From: Jean Fraser
To: Stephen Bushey
CC: DiPierro, Philip
Date: 2/16/2016 4:43 PM
Subject: RE: 421 Warren Avenue Site plan revision
Attachments: c-3.0 site layout and utility plan.pdf; App C-3.1 Lighting and Photometrics Plan.pdf

There are three concerns that I would like to have addressed with amended plans (or notes on the plans) before I issue an approval letter for the amendment.

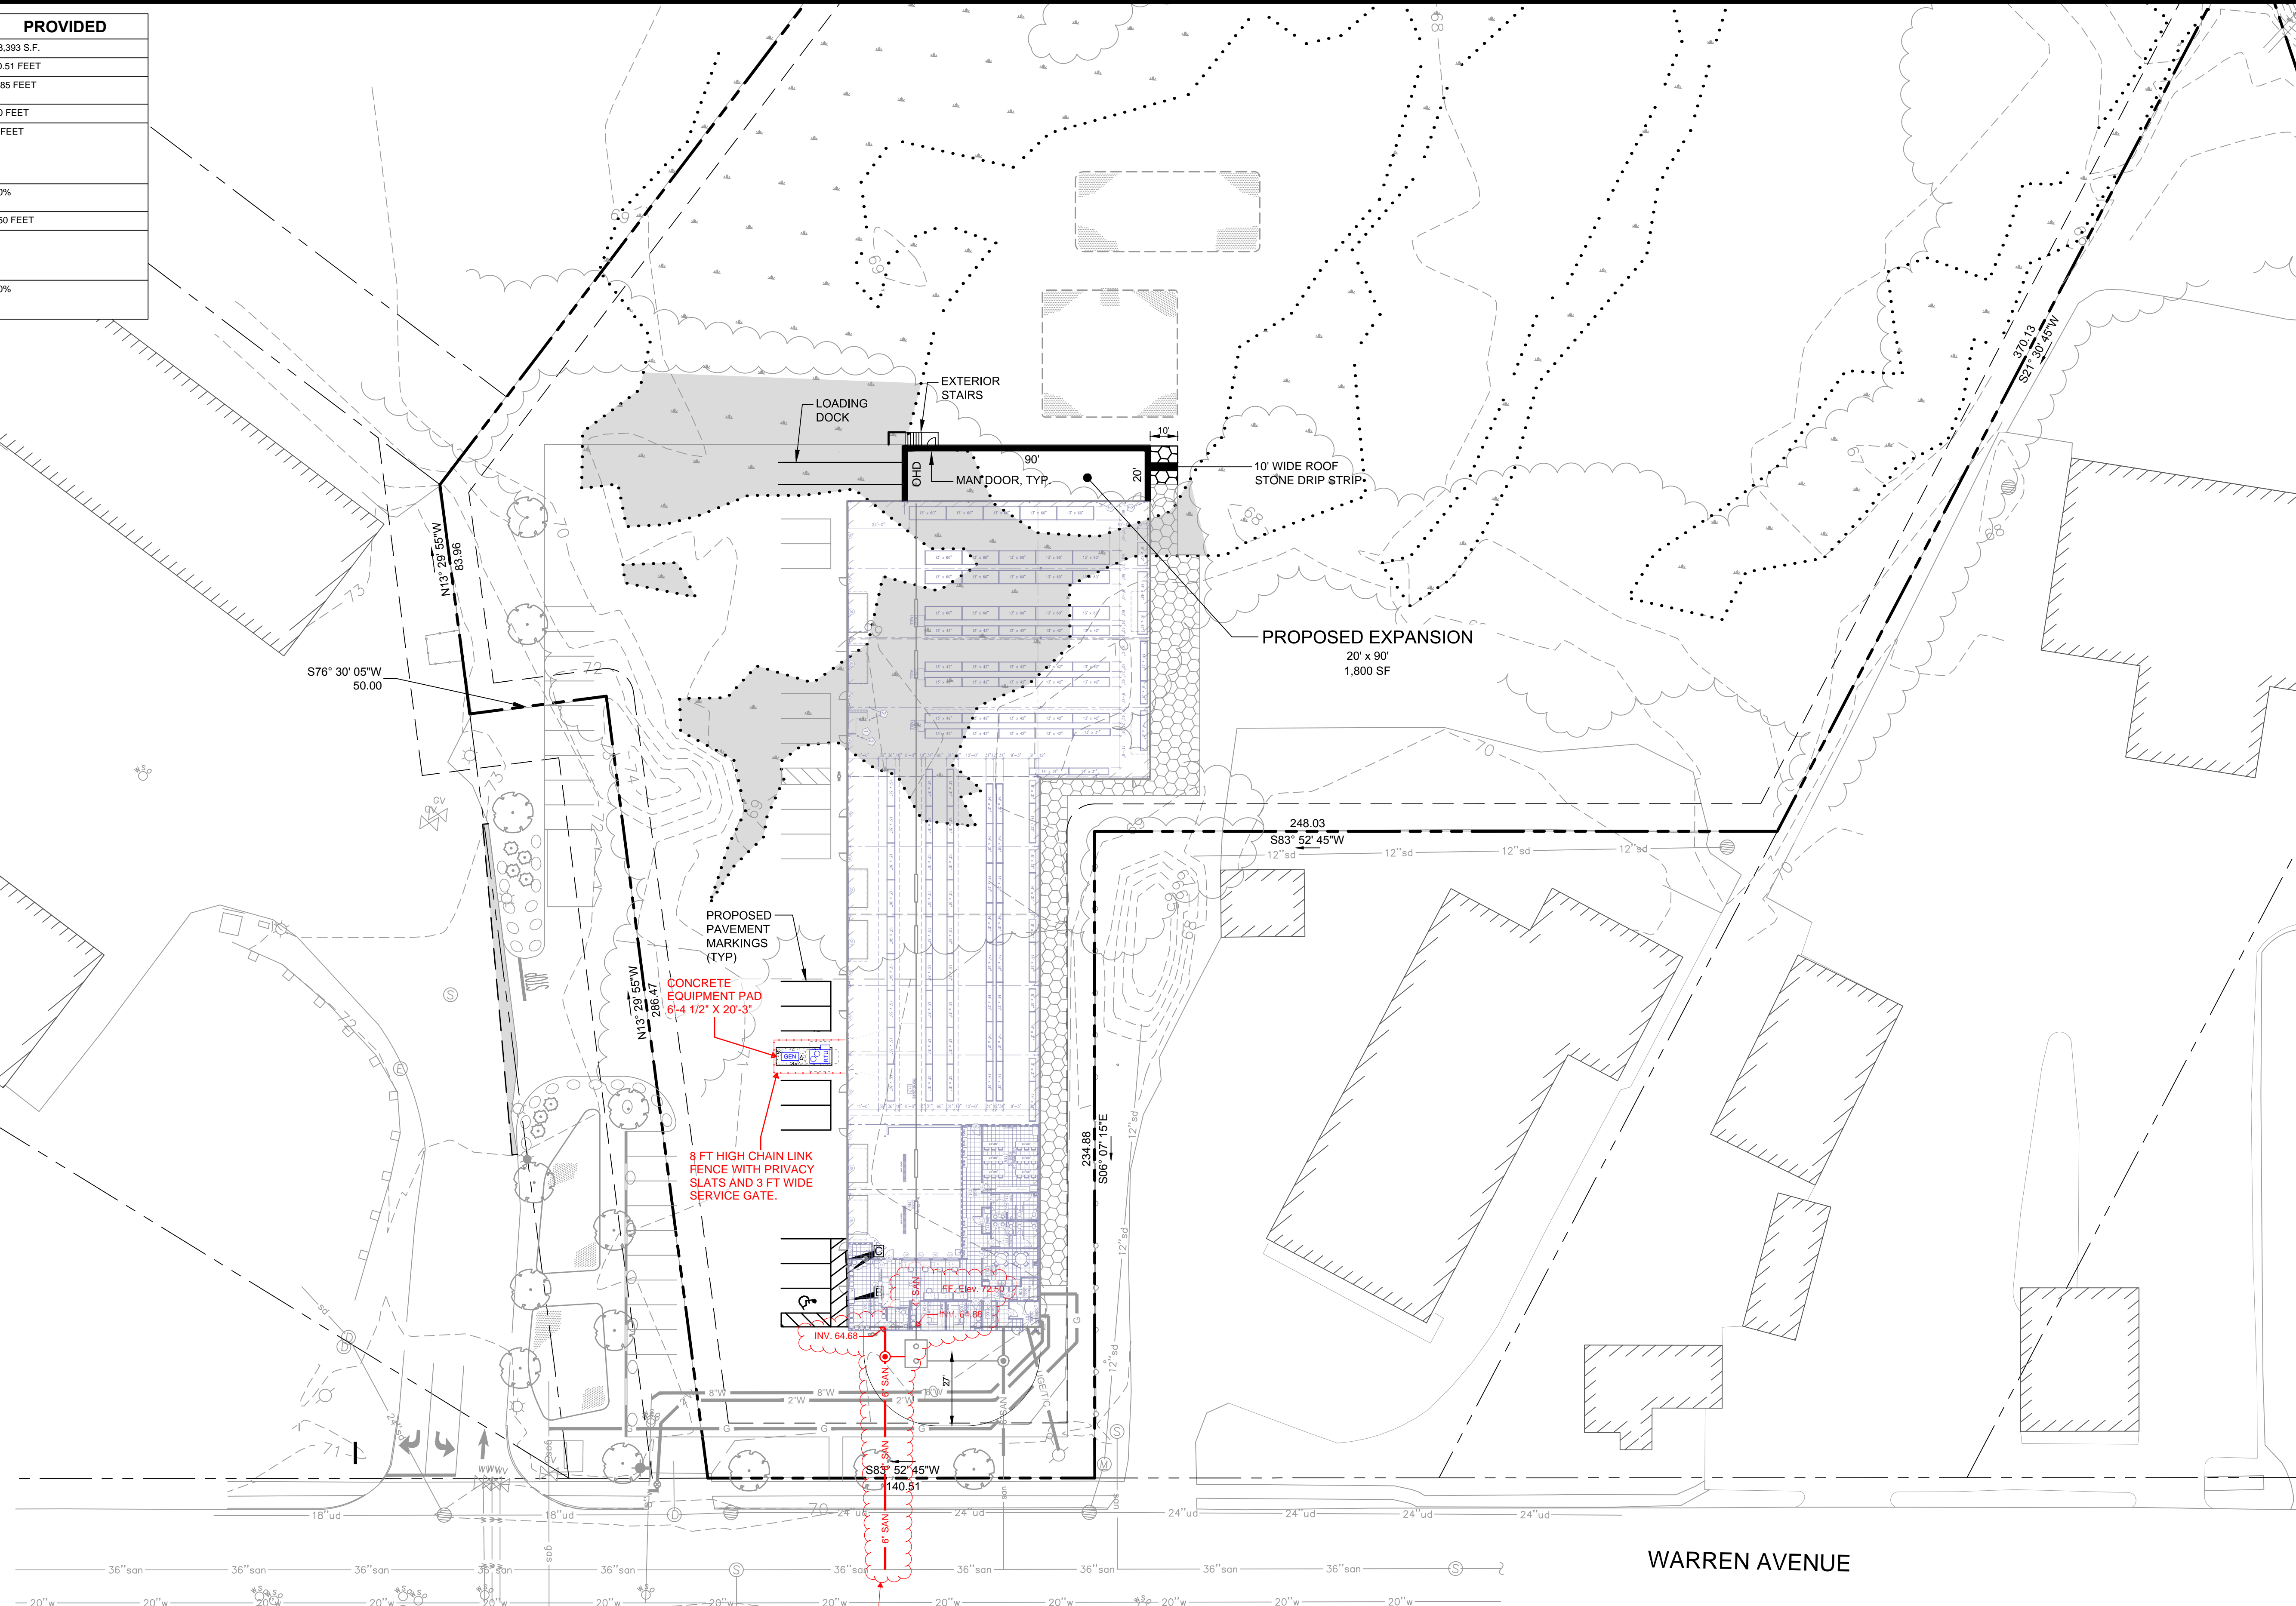
Location and baffling of the new generator: The B4 zone includes noise limits of 60 DbA night and 65 DbA day and its location so near the boundary may make that difficult. Also it needs some kind of screening or enclosure. I would like to see the specs for the sound generation (when operating) for that unit as my experience tells me its may be too close to the boundary. Could it go farther back on the site?

Parking: Please amend the site plan (attached) so that there is no parking shown in front of the garage doors and main entrance for the two bay in-shop area for glass repairs with a customer waiting area. The area in front of the entrance door should be striped and ideally there should be ADA access and ADA parking for customers waiting to go into the bay. Maybe a sign saying "customer parking" so those spaces get reserved?
